## MEMORANDUM

**DATE:** February 8, 2018

**RE:** 11 Stevens Avenue Appeal

**Sketch Floor Plan Showing Existing Exits**

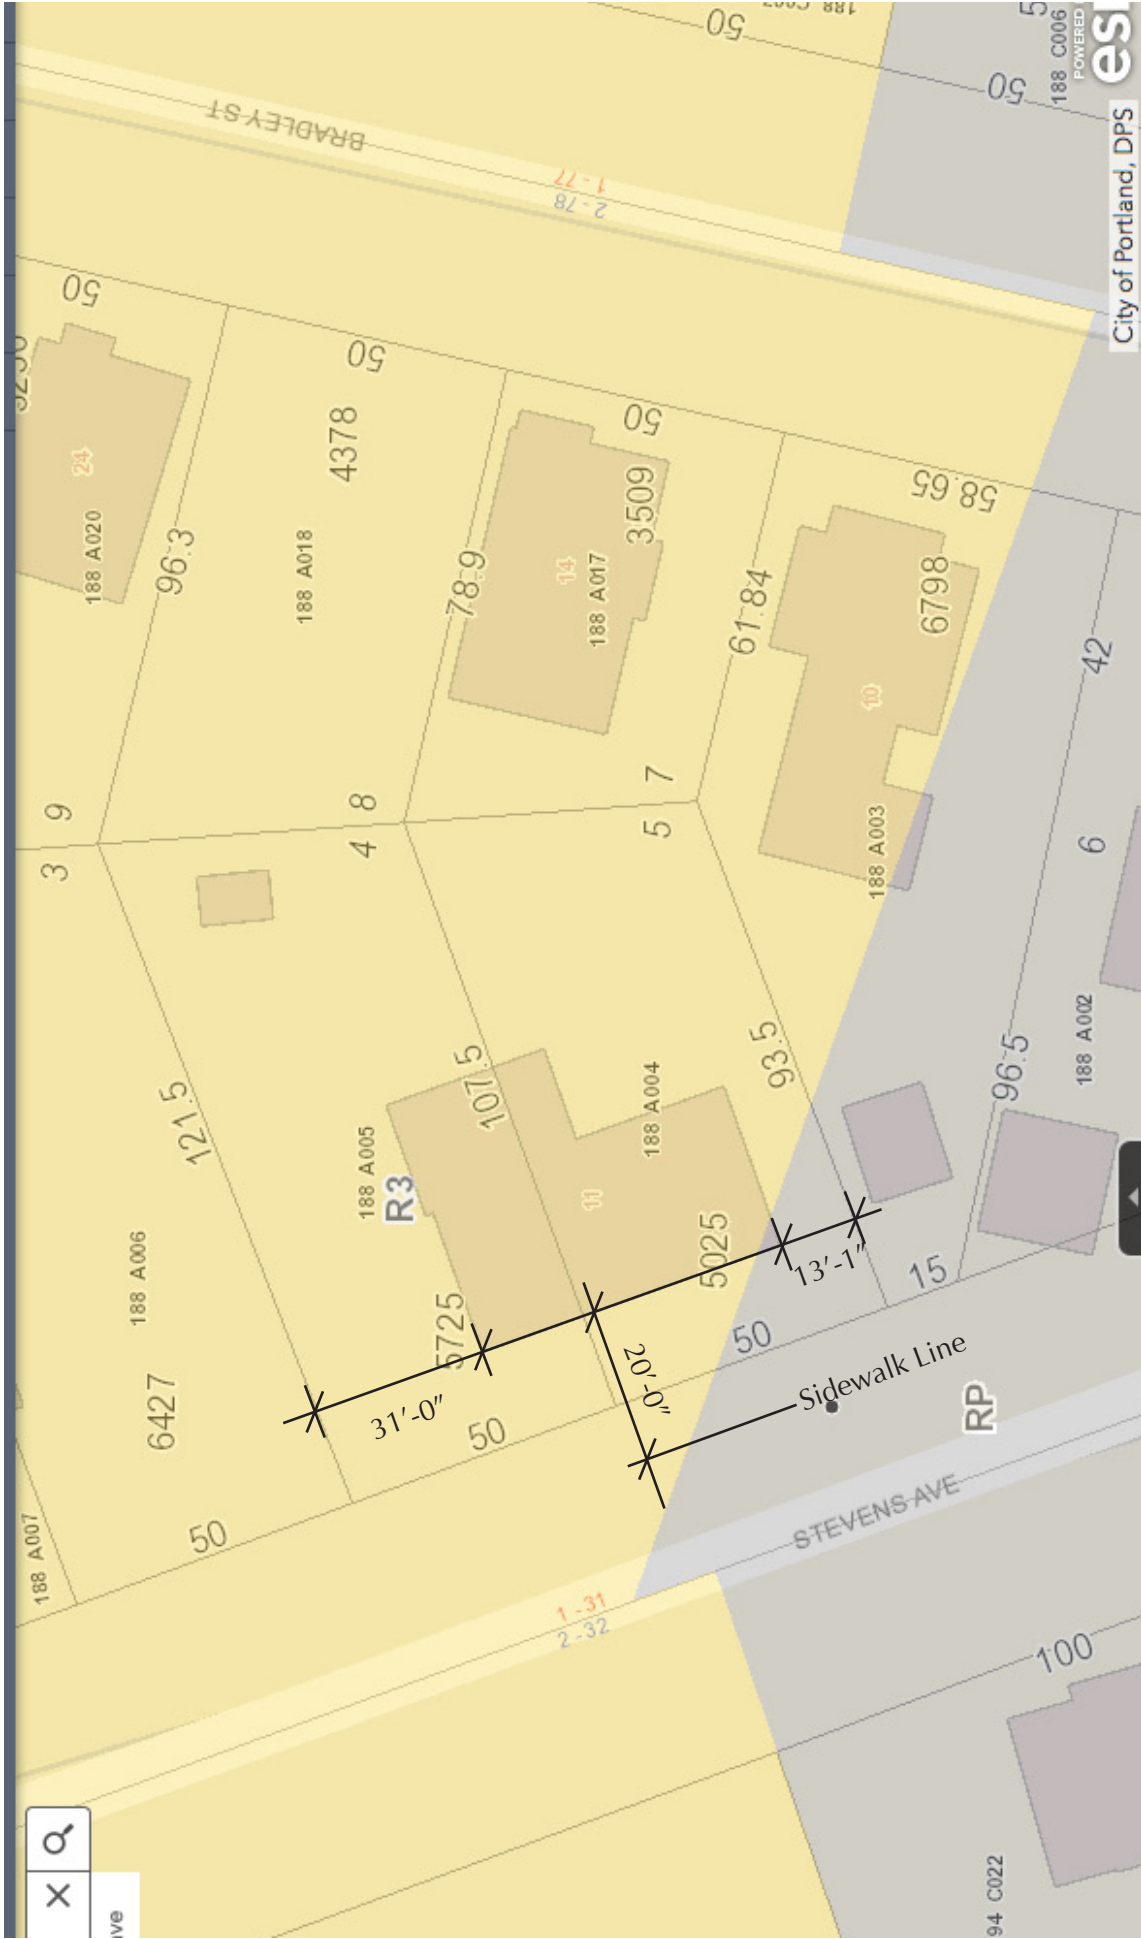
Ms. Gaertner has claimed that she has the required two means of escape because she has two different doors leading from her bedroom. However, as Matt will explain further at the meeting, these doors do not provide two means of escape that are “independent and remote” from each other. Excerpts from the NFPA 101 Handbook, explaining further the requirements of independence and remoteness are also attached.

Because Ms. Gaertner does not have two means of escape that are independent and remote from each other, she must replace the window in her bedroom to provide for that second means.
